**Section 96A of the Town & Country Planning Act 1990 (as amended)
Town and Country Planning (Development Management Procedure) (England) Order 2015
(as amended) - Article 10**

Non-material amendment following grant of AW/380/21/HH for the omission of rear door & provision of french doors; addition of roof lantern over kitchen; additional window to North elevation; revised ground floor layout; revised 1st floor layout and reduction in height of front 1st floor window frame.

130 Nyetimber Lane Aldwick PO21 3HR

sheet 1 a of 4

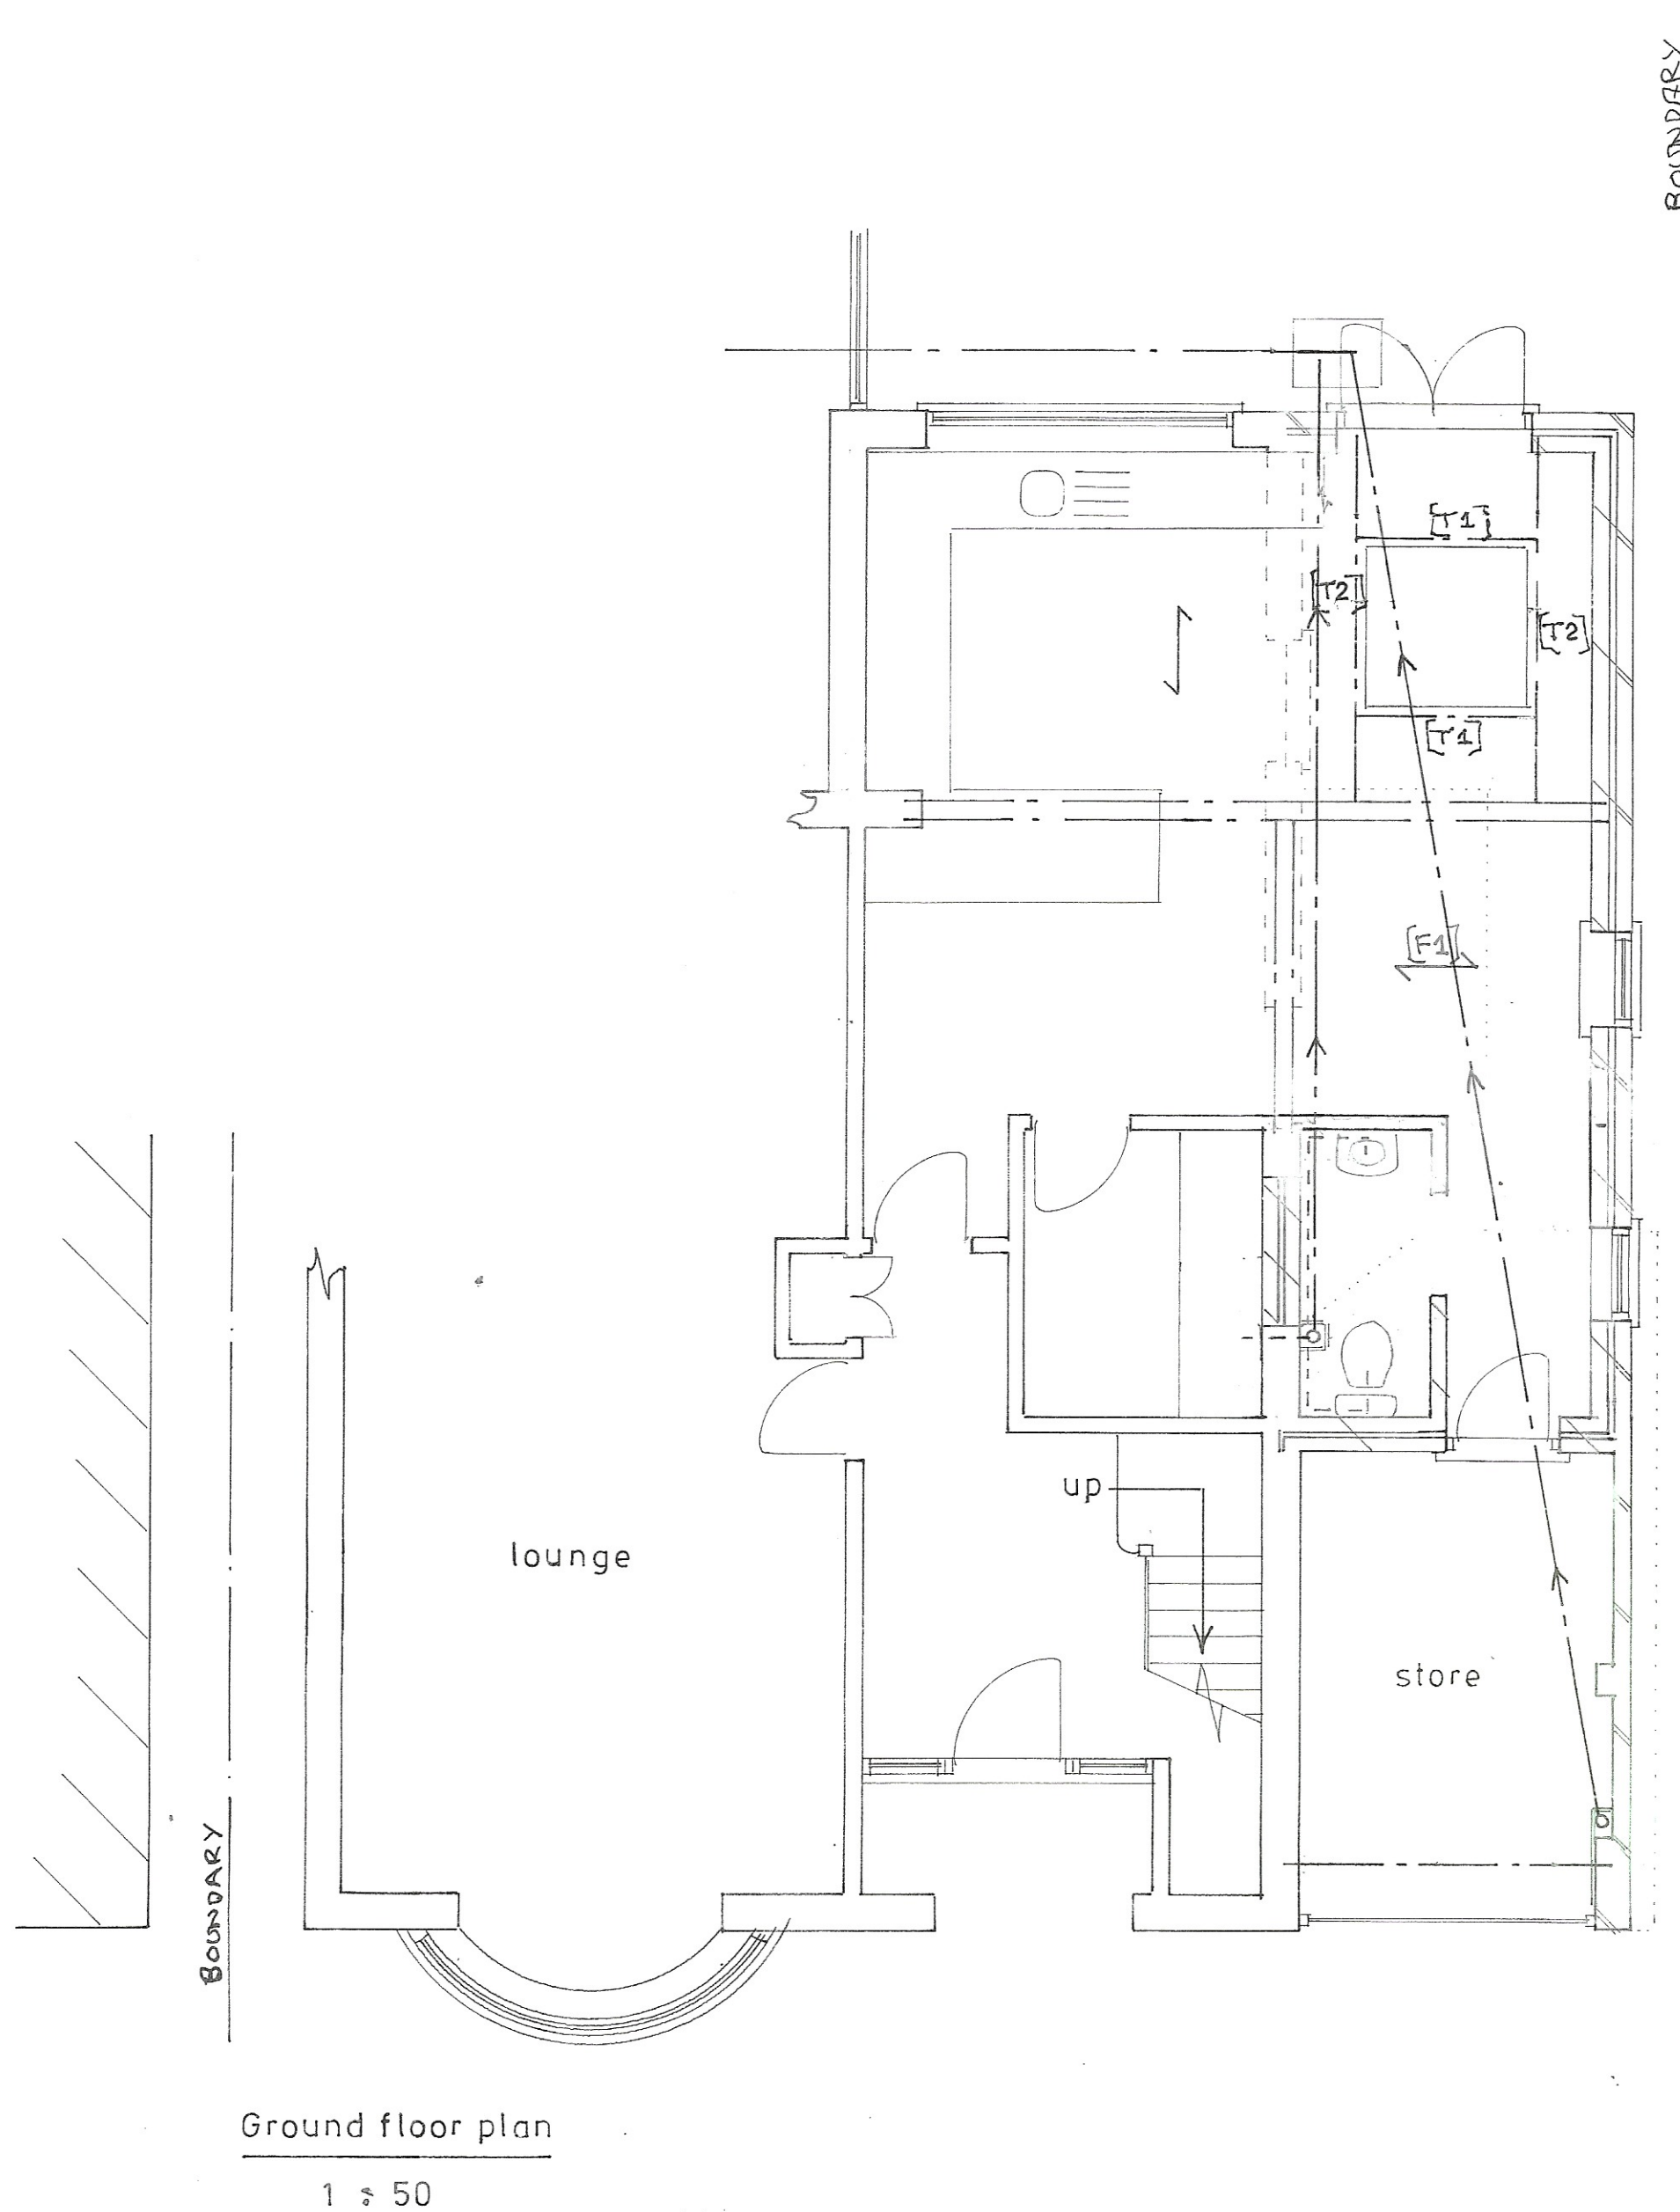
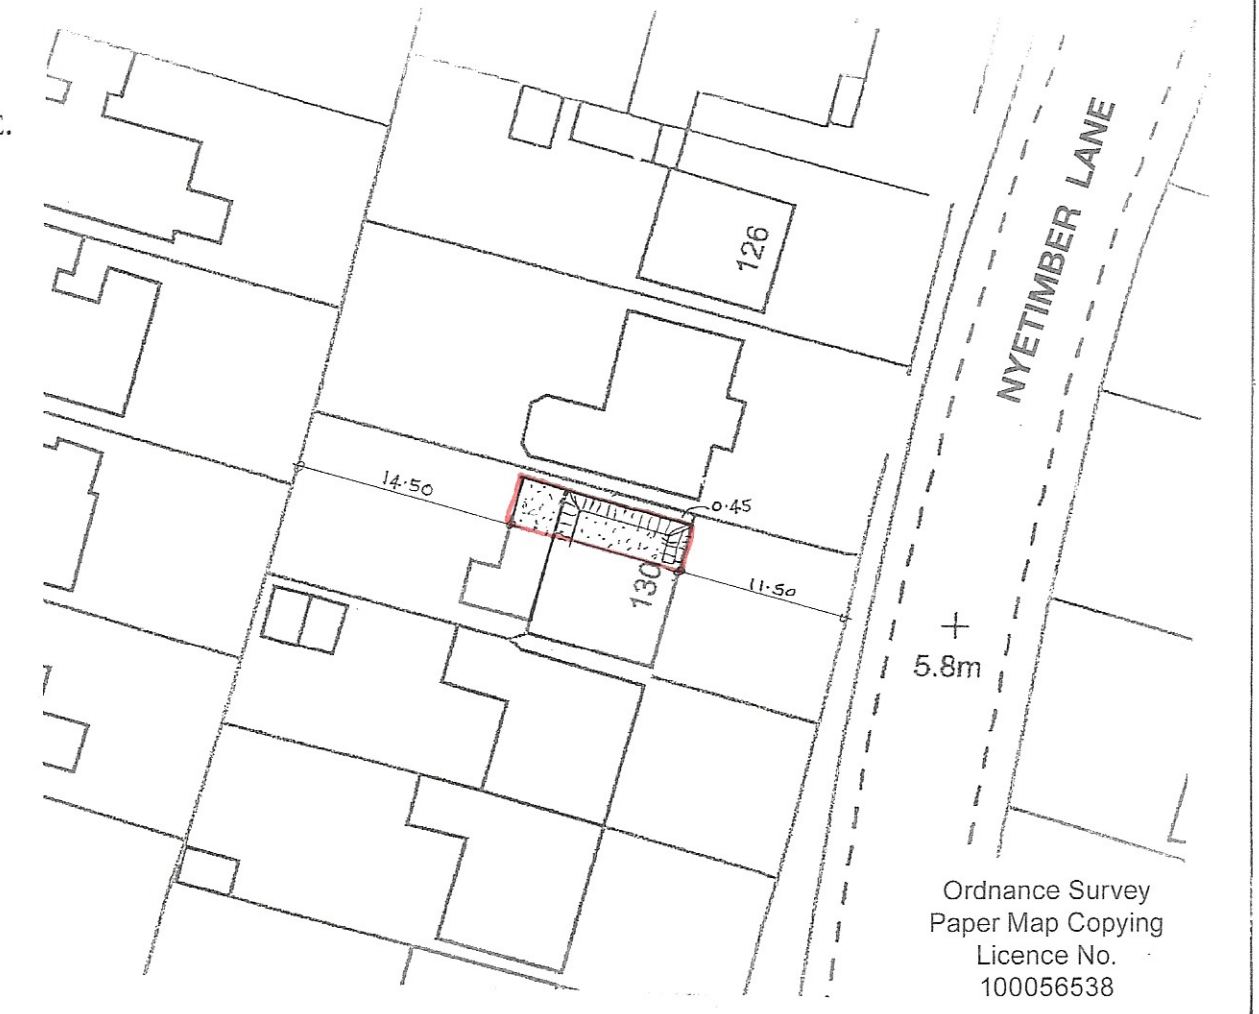
- Alteration of rear facing door to French door.
- Addition of roof lantern over the rear extension.
- Revised internal ground floor and 1st floor layout.
- Alteration to the height of the 1st window frame.

- Location, Block and Proposed Ground Floor Plan - Sheet 1a
- Proposed First Floor and Elevation - Sheet 2a
- Proposed Roof Plan - Sheet 4b
